Item No. **Report of the Head of Planning, Transportation and Regeneration**

Address 63-65 STATION ROAD HAYES

Development: First floor rear extension and creation of 1 x 1-bed self contained flat

LBH Ref Nos: **18175/APP/2020/544**

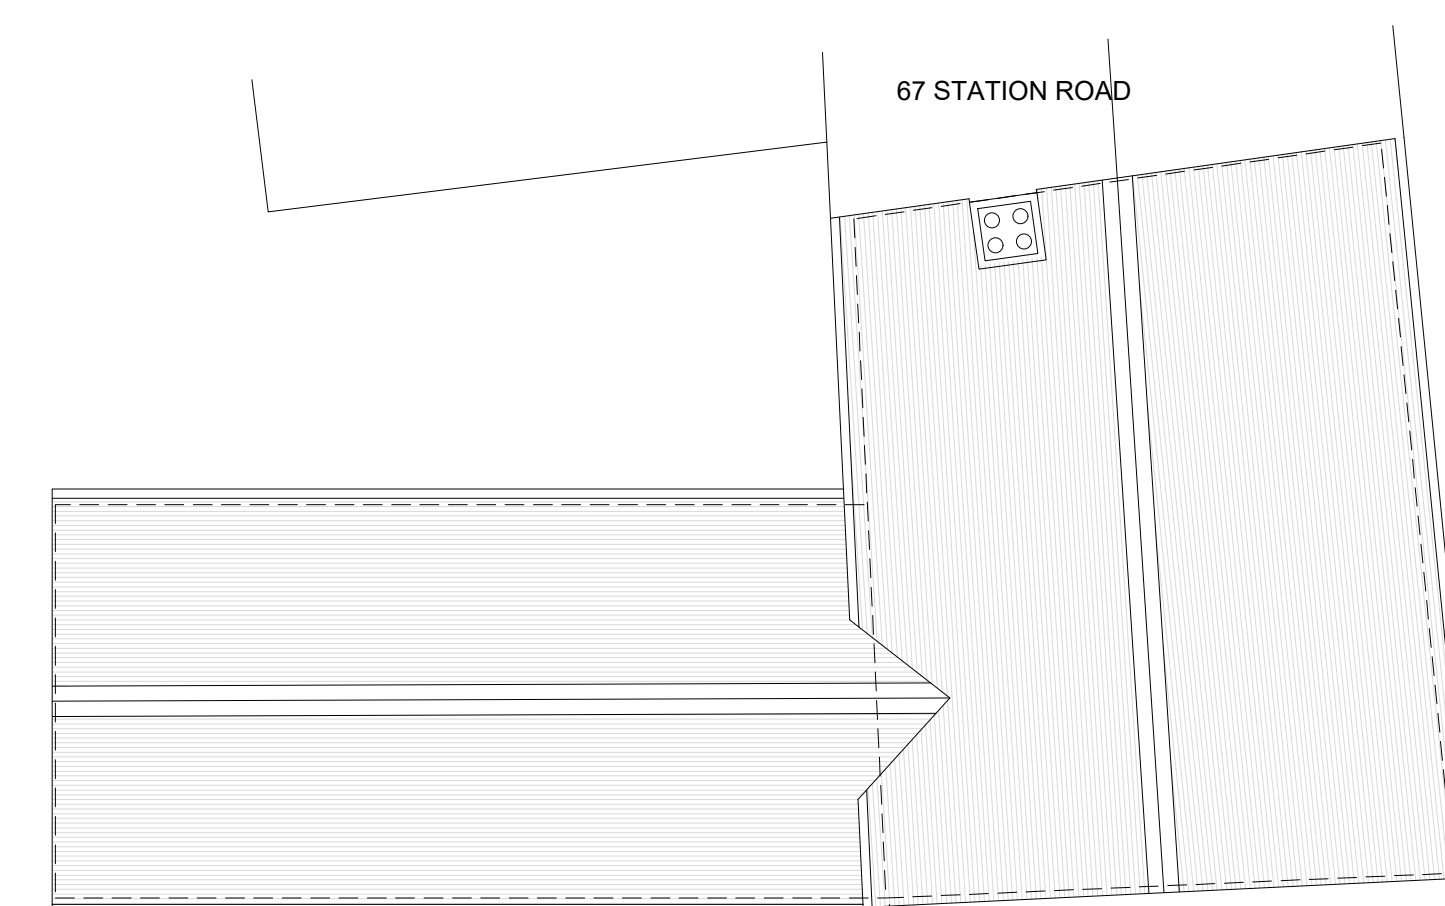
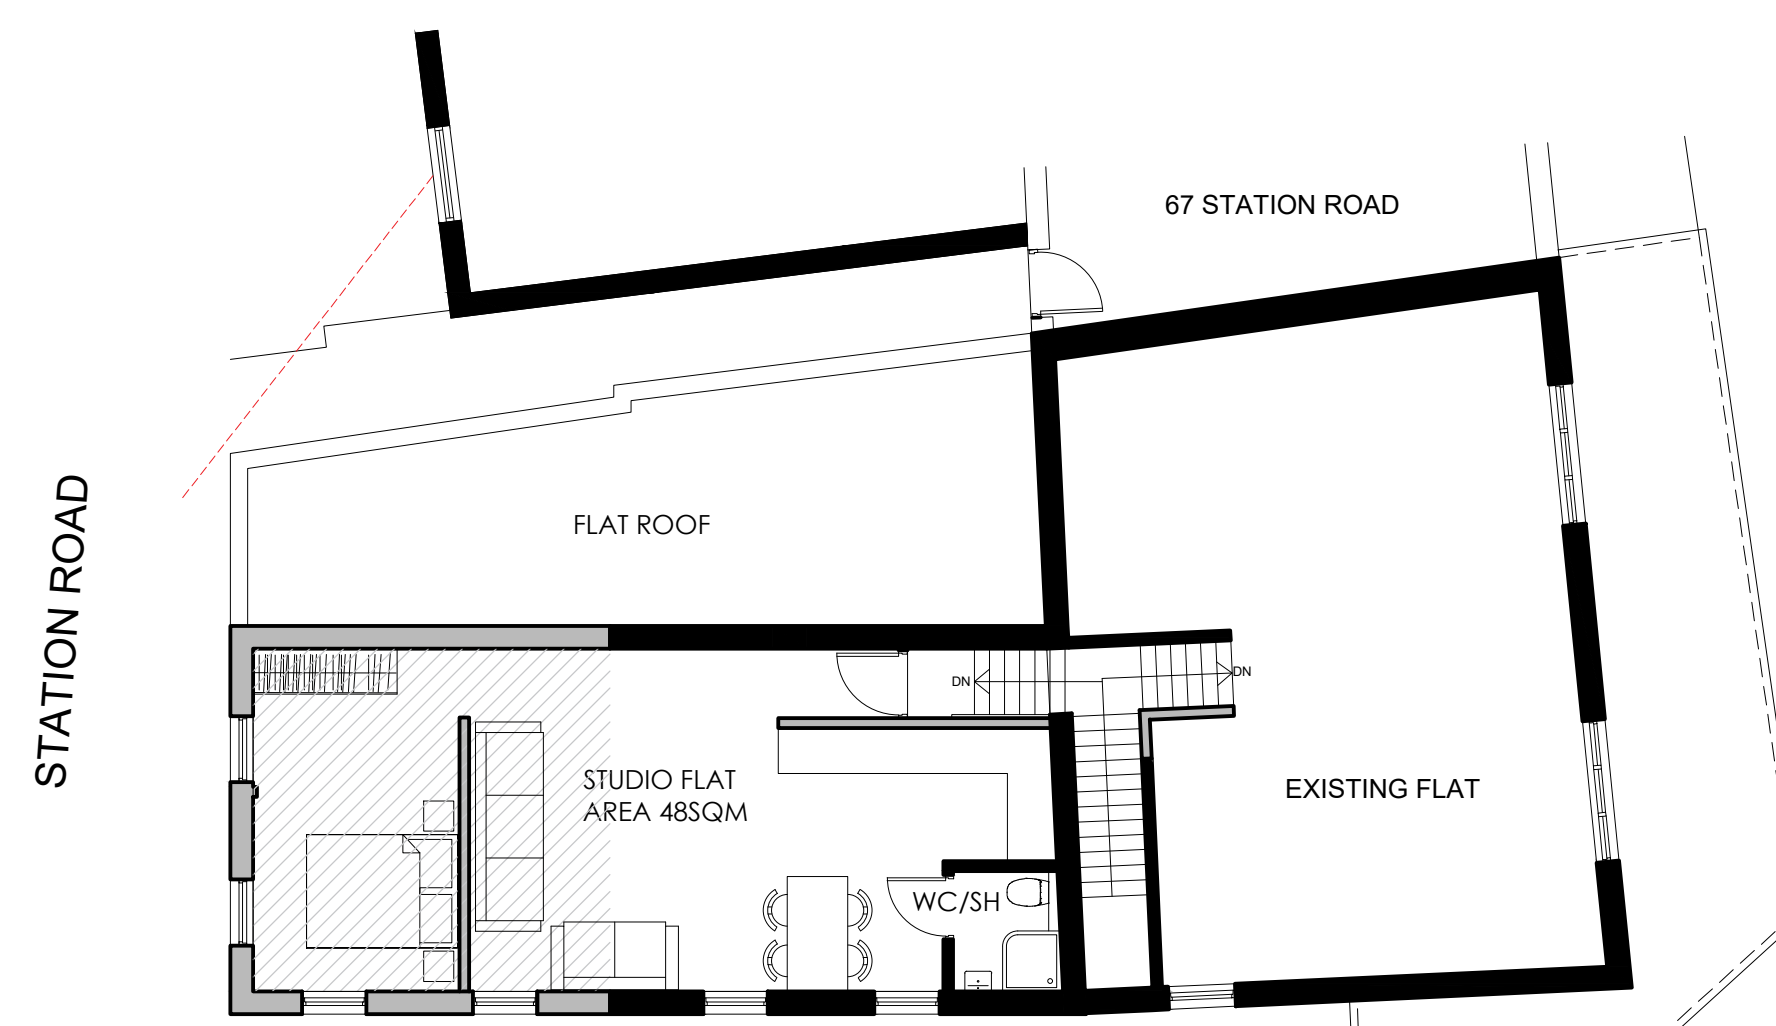
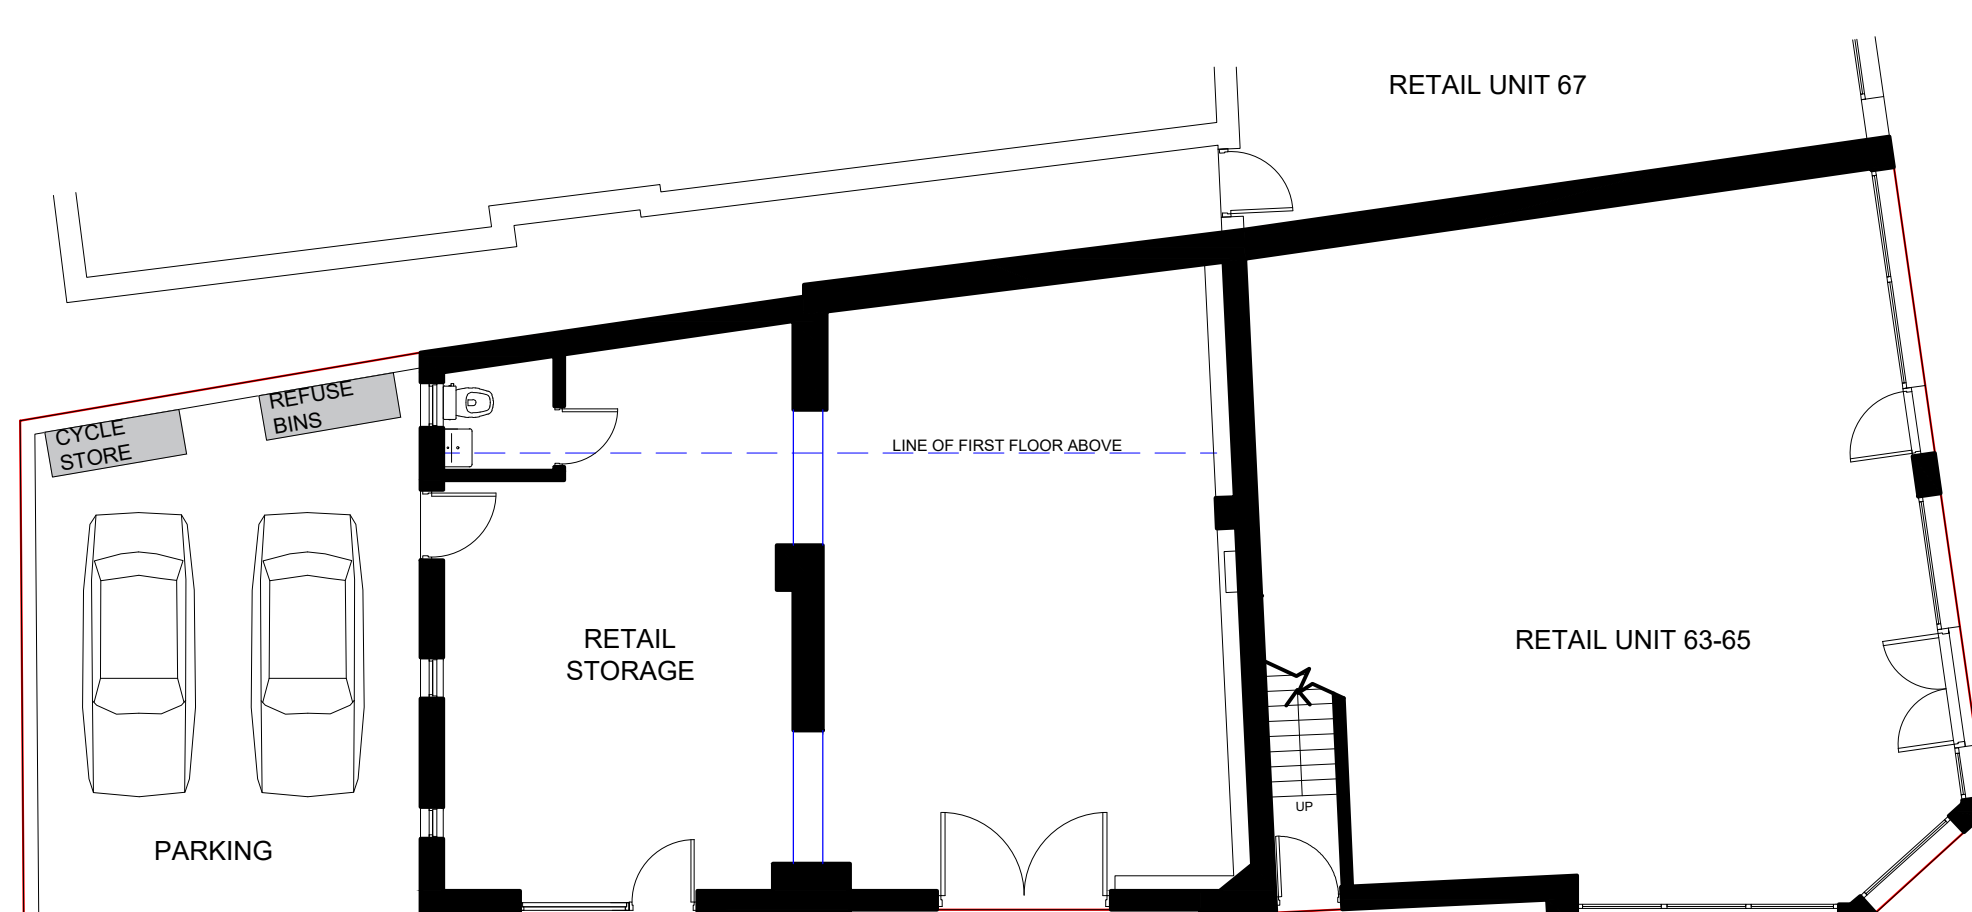
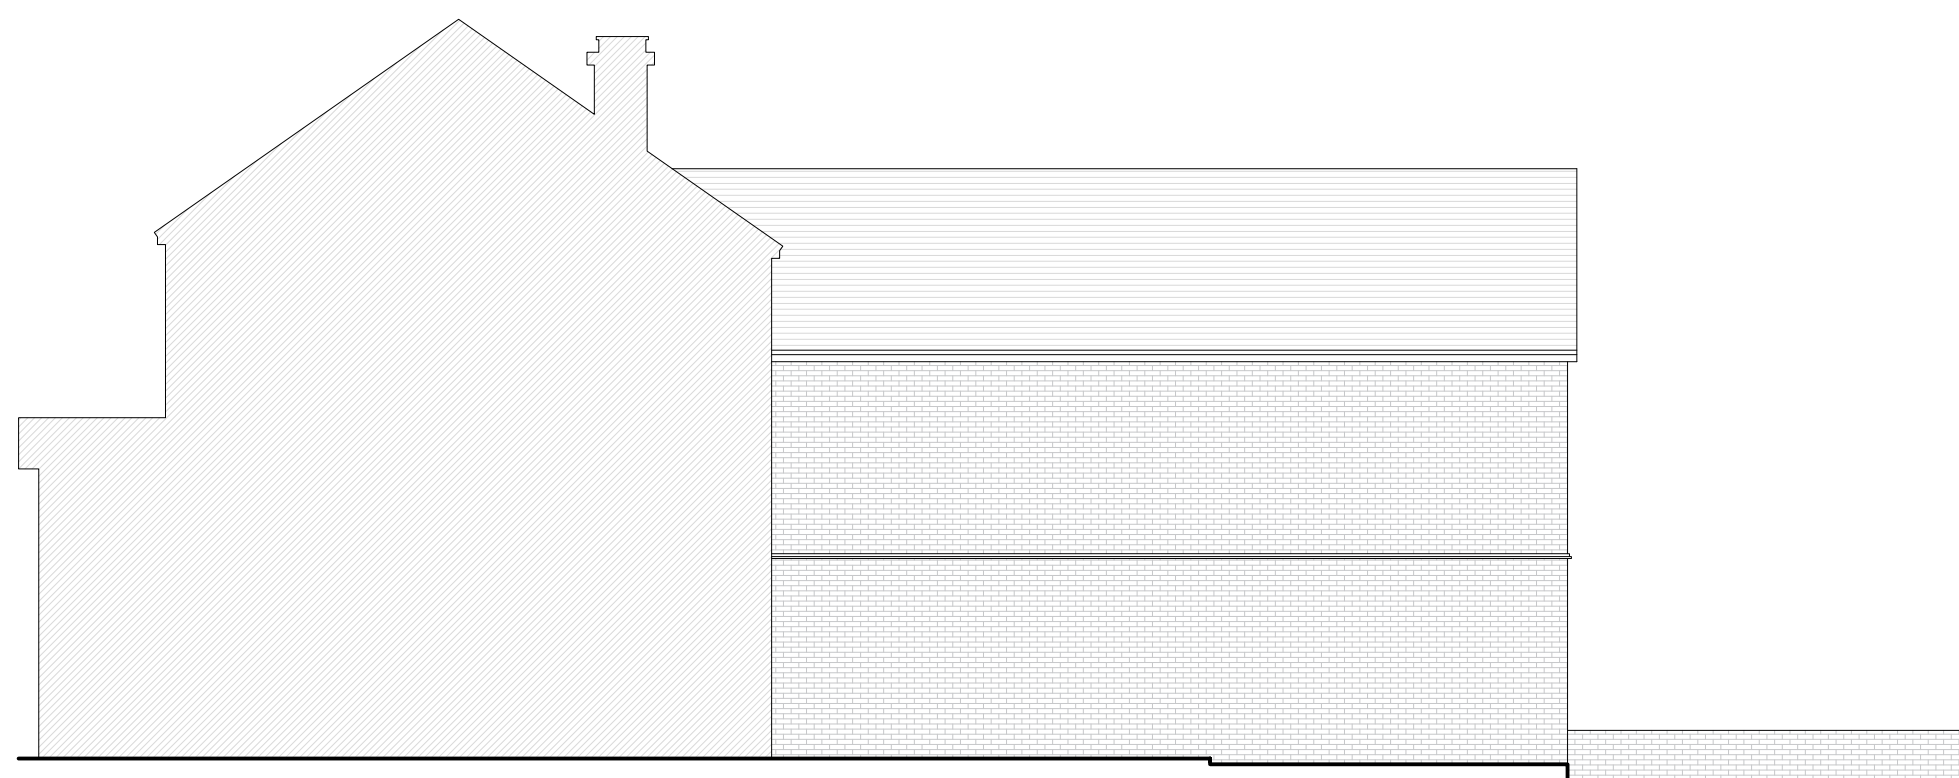
The application seeks planning permission for the erection of a first floor rear extension and creation of 1 x 1-bed self contained flat. The proposal seeks to address the concerns raised by an Inspector in a recent appeal. It is considered that the proposal fails to address the concerns in terms of the impact of the proposal on the residential amenities of the occupants of the flat at Number 67A Station Road.

The proposed development, by reason of its overall siting, size, scale and bulk would result in an overdominant and visually obtrusive form of development in relation to the existing adjoining occupiers of the first floor flat at 67 Station Road and as such would constitute an un-neighbourly form of development, resulting in a material loss of residential amenity. The proposal is therefore contrary to Policies DMHB 11 and DMHD 1 of the Hillingdon Local Plan: Part Two - Development Management Policies (January 2020).
